From: Mark Warwick
Sent: 31 May 2019 15:05
To: Michael Eastham
Subject: A/40/18/OUT - Suggested condition in respect of Retained Tree Protection Measures

**Drawing title:** Tree Retention Plan

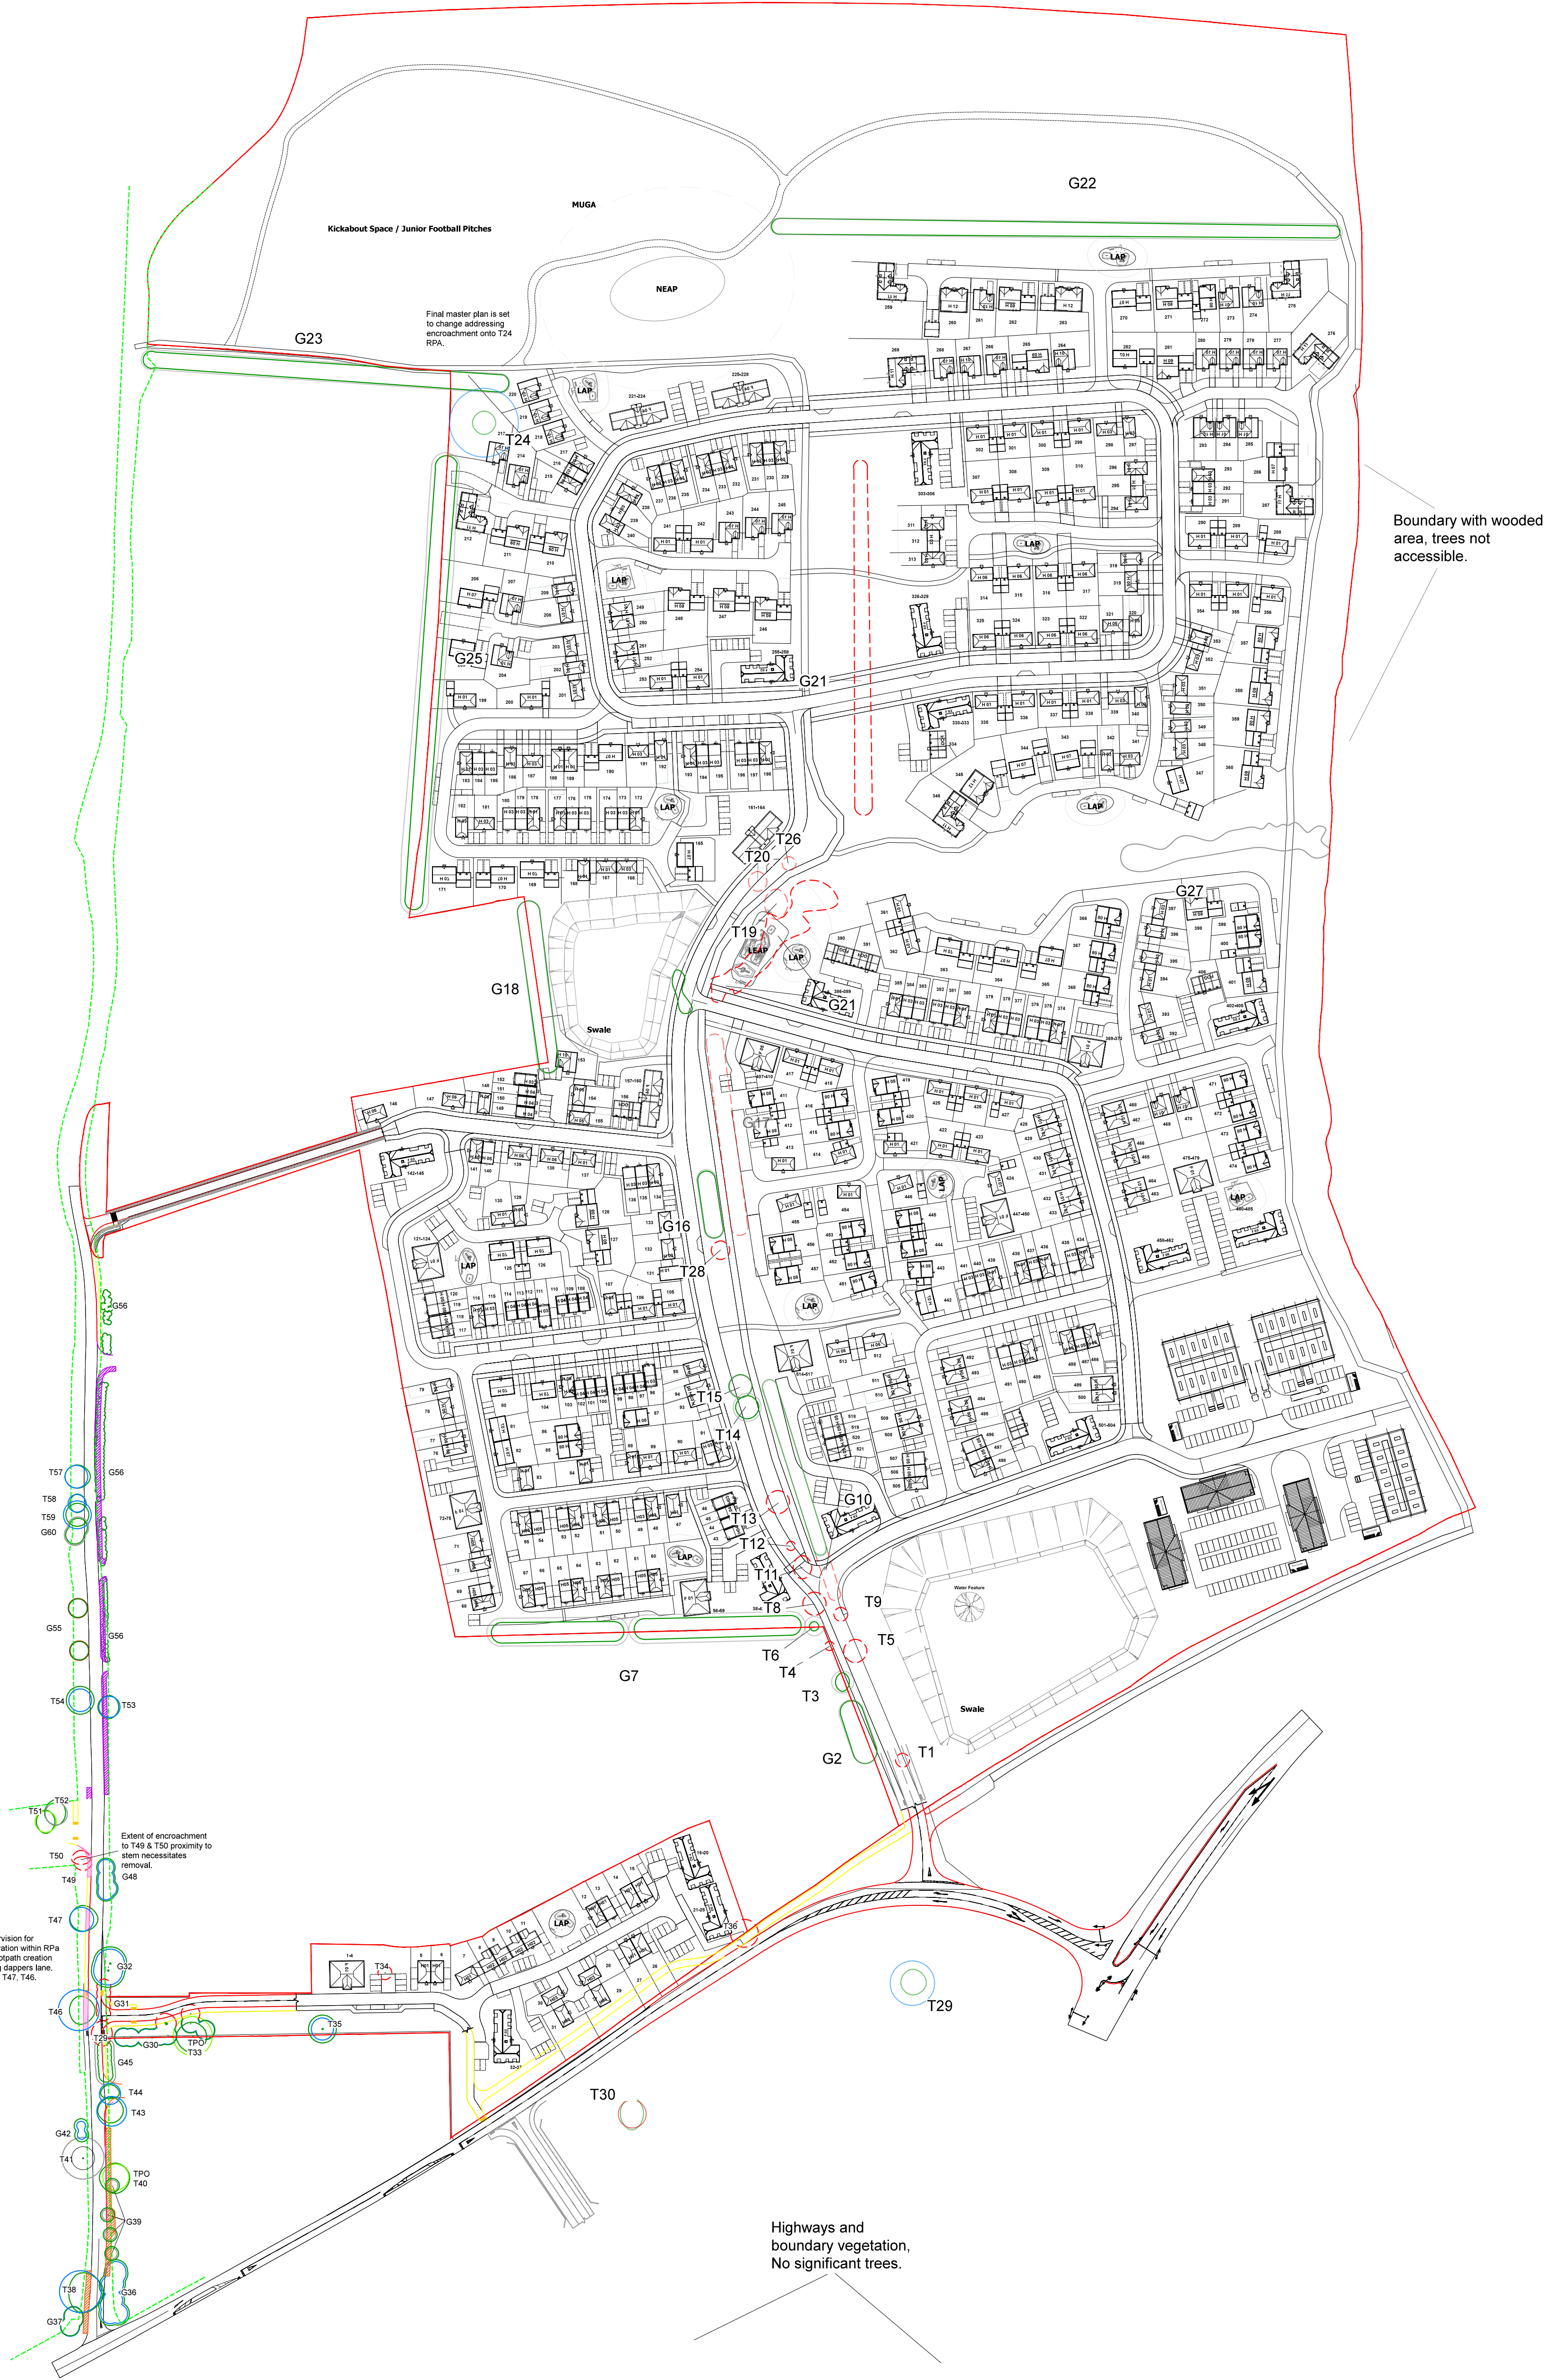
In the event that a RPA of any tree which is proposed for retention overlaps the development then BS5837:2012 requires that the Detailed Planning Application is accompanied by an Arboricultural Method Statement (AMS) and also most importantly a Tree Protection Plan – to both describe and illustrate the mitigation measures which are to be employed to ensure that the trees survive without detriment to their vigour and vitality and are given adequate protection both above and below ground.
